FINAL DRAINAGE REPORT for

Legacy Church
10460 W Hwy 24,
Green Mountain Falls, CO

PCD File No. PPR1933

Prepared: July 19, 2019
Resubmitted: September 17, 2019
Resubmitted: October 18, 2019
Resubmitted: November 22, 2019

REV: 11/22/19
REV: 10/18/19
PROPOSED DRAINAGE PLAN
SHEET 2 OF 3

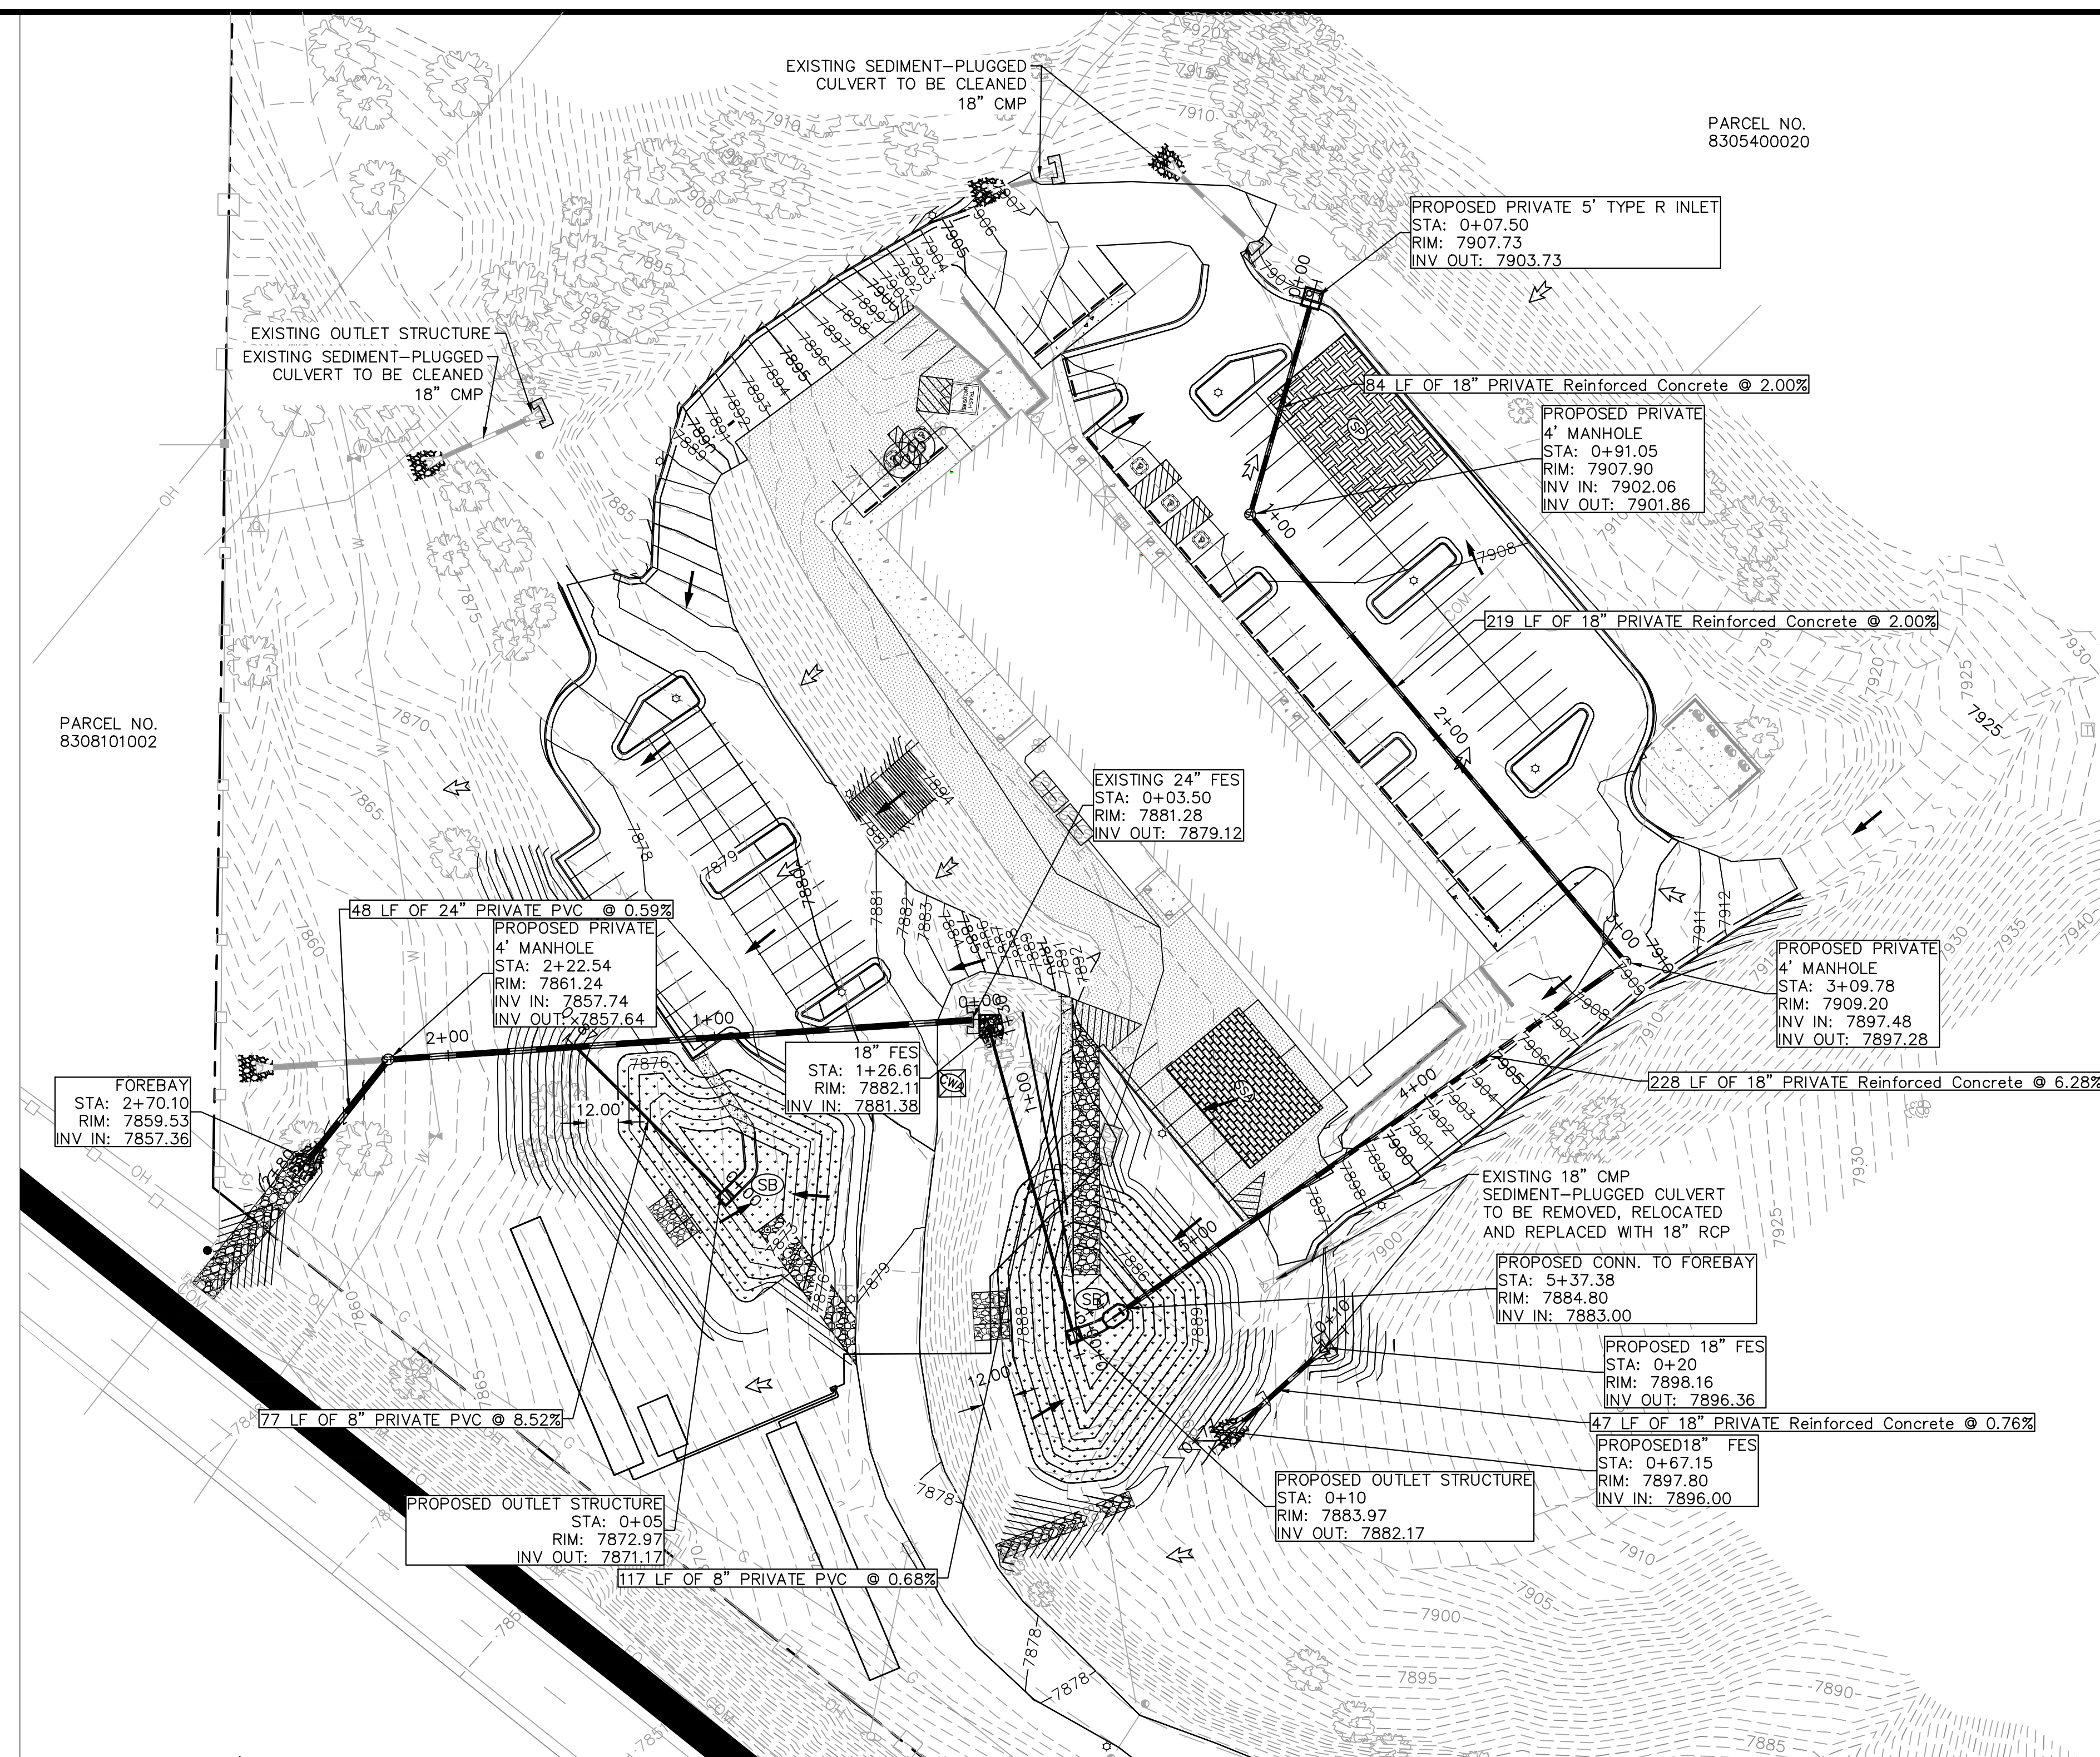
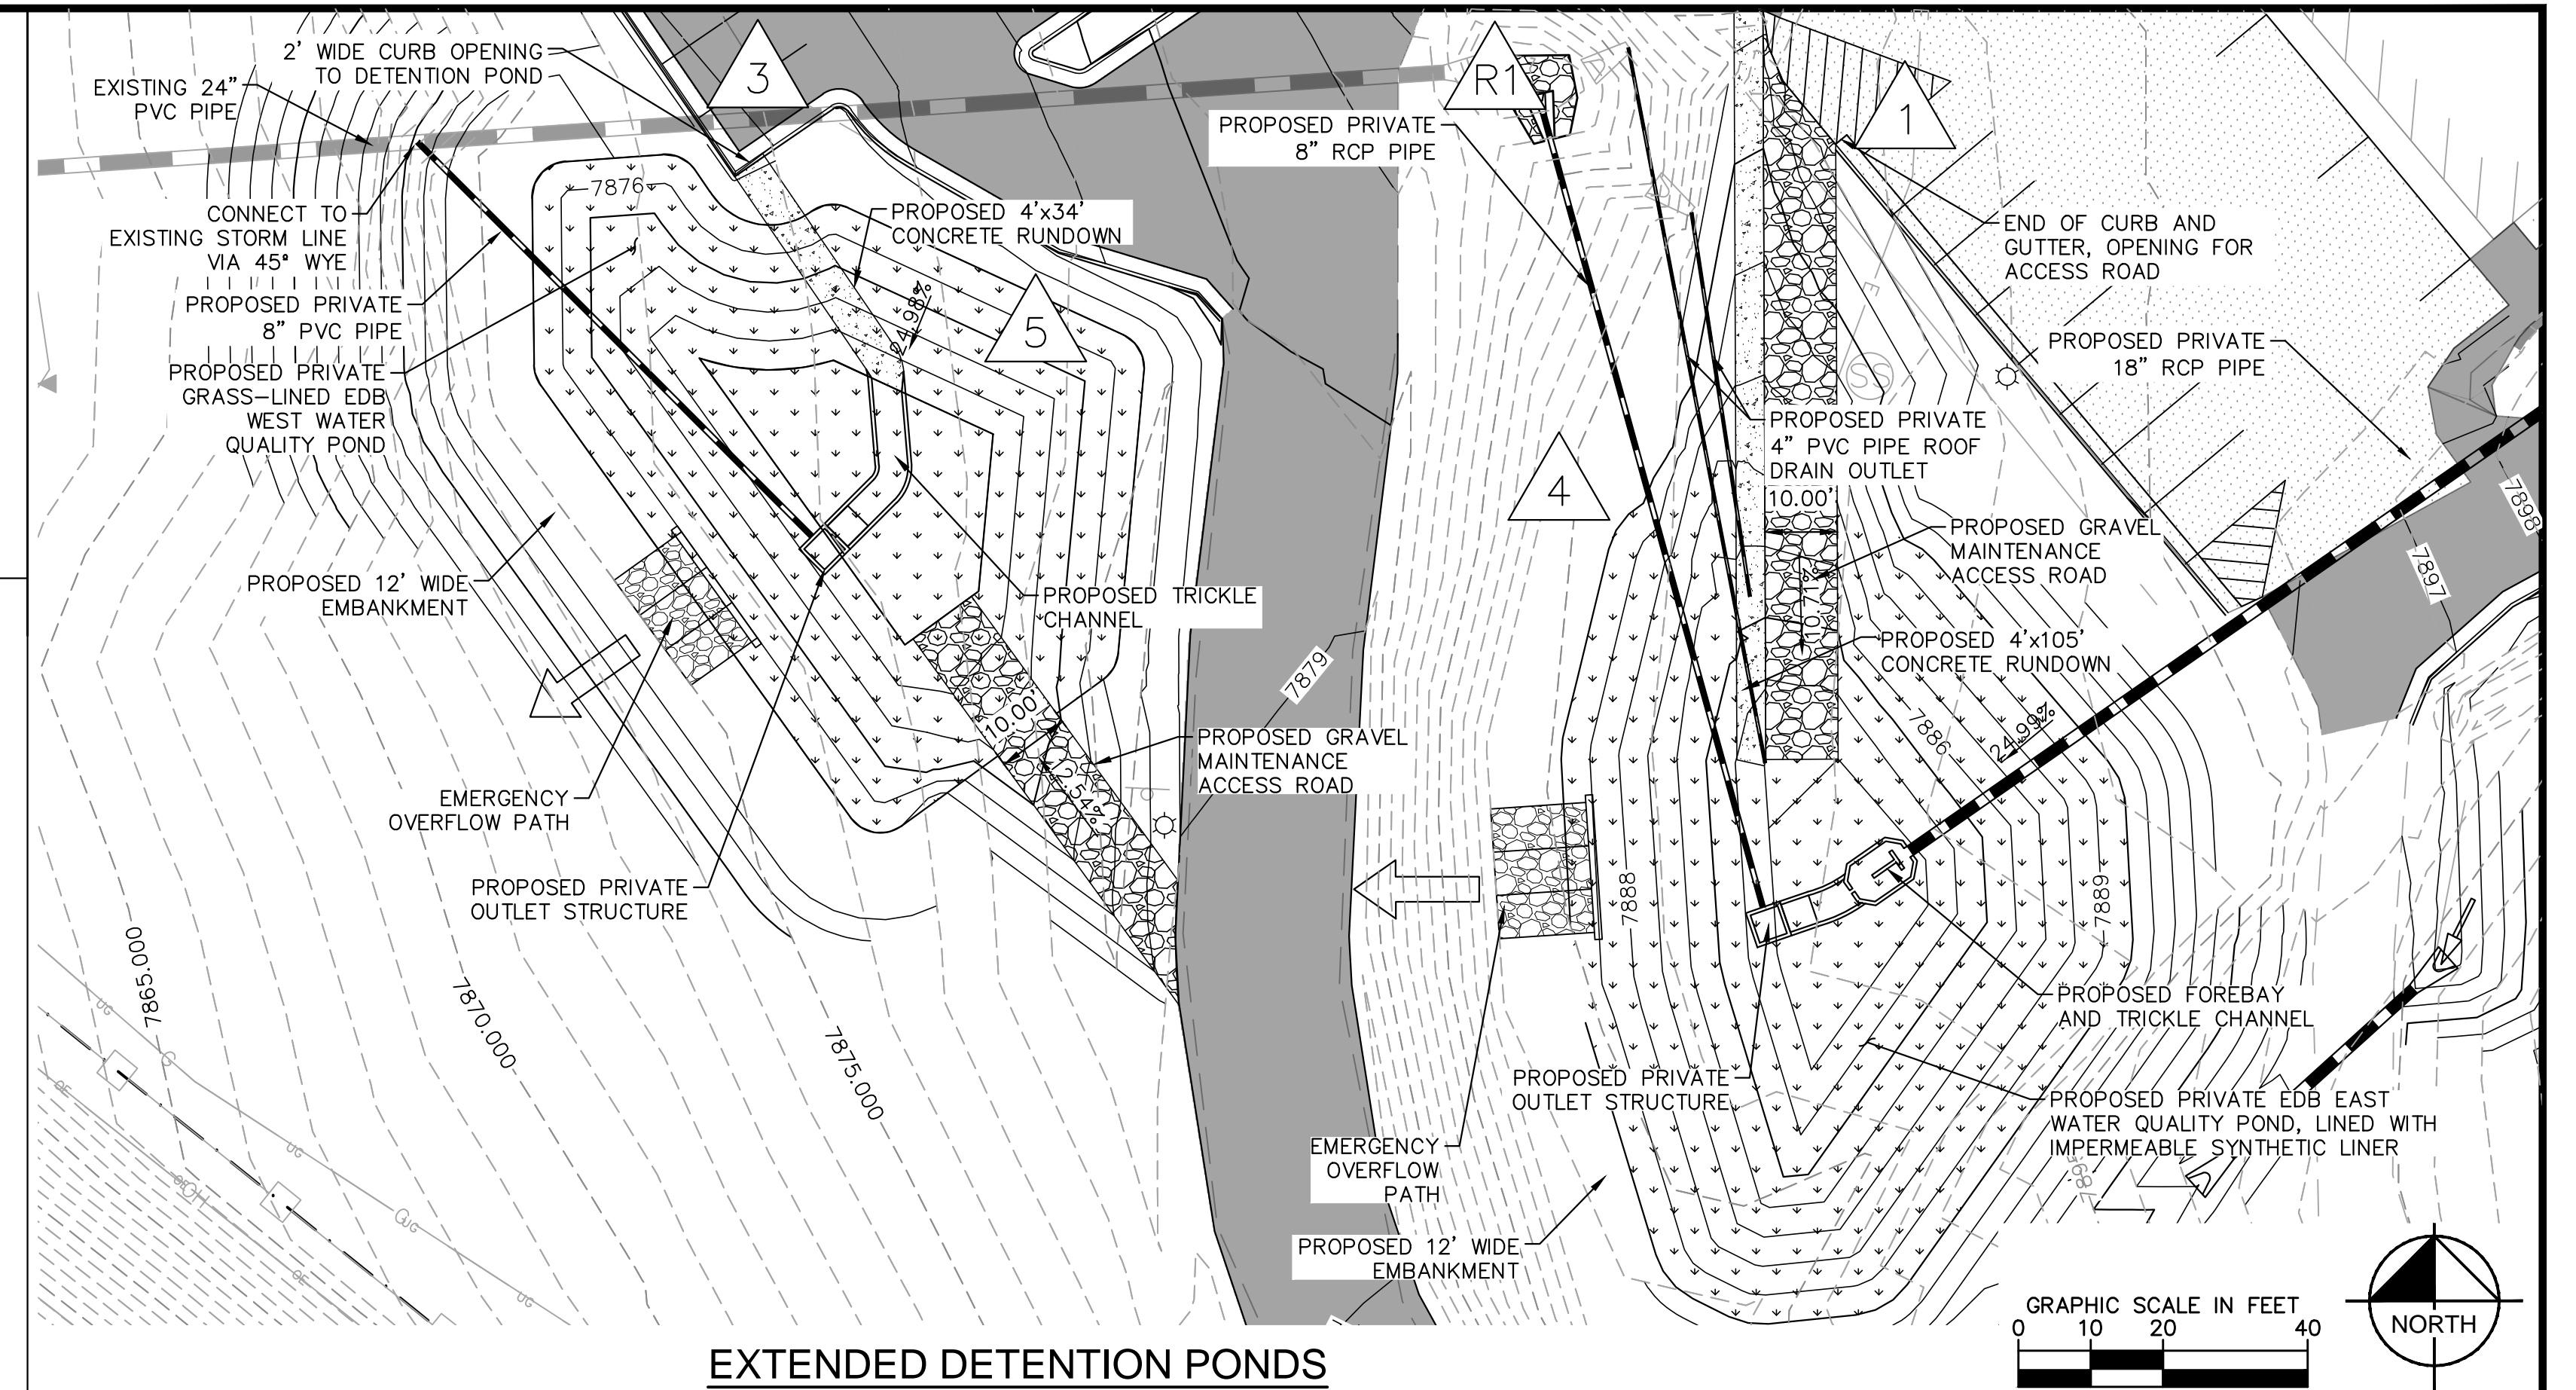
The drainage plan shows proposed grading in this area to divert the offsite flow away from the pond. Also the drainage plan indicates that the existing culvert will be relocated and there appears to be protection provided downstream. Please include a description of this in the narrative.
